**From:**  
**Sent:** 17 June 2024 13:52  
**To:** DCAdmin  
**Subject:** 2024/62/91242/E

I wish to object to the proposed development.

HOUSE TYPE PACK

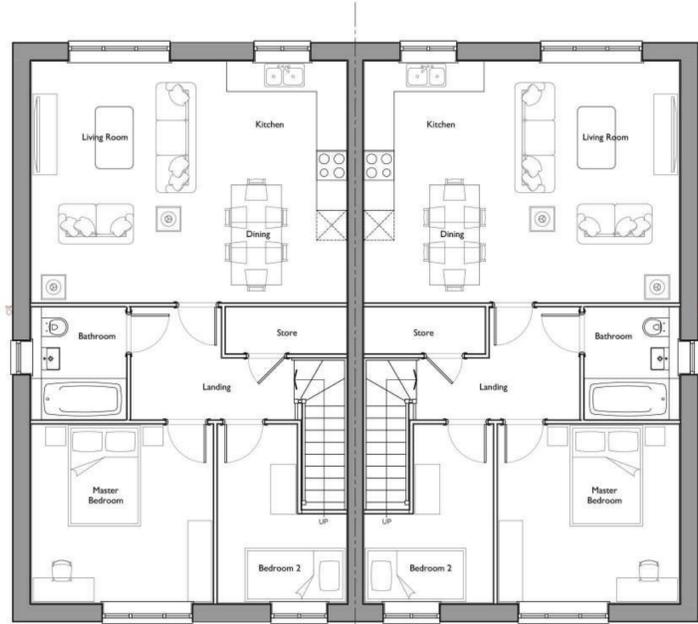
3. A development of 50 houses is far too big for what is essentially a hamlet. Moreover, the proposed development does not reflect the character of the village in terms of design (materials used are not local and are not individual). The proposed development contains too many large houses, rather than affordable properties which the area lacks.
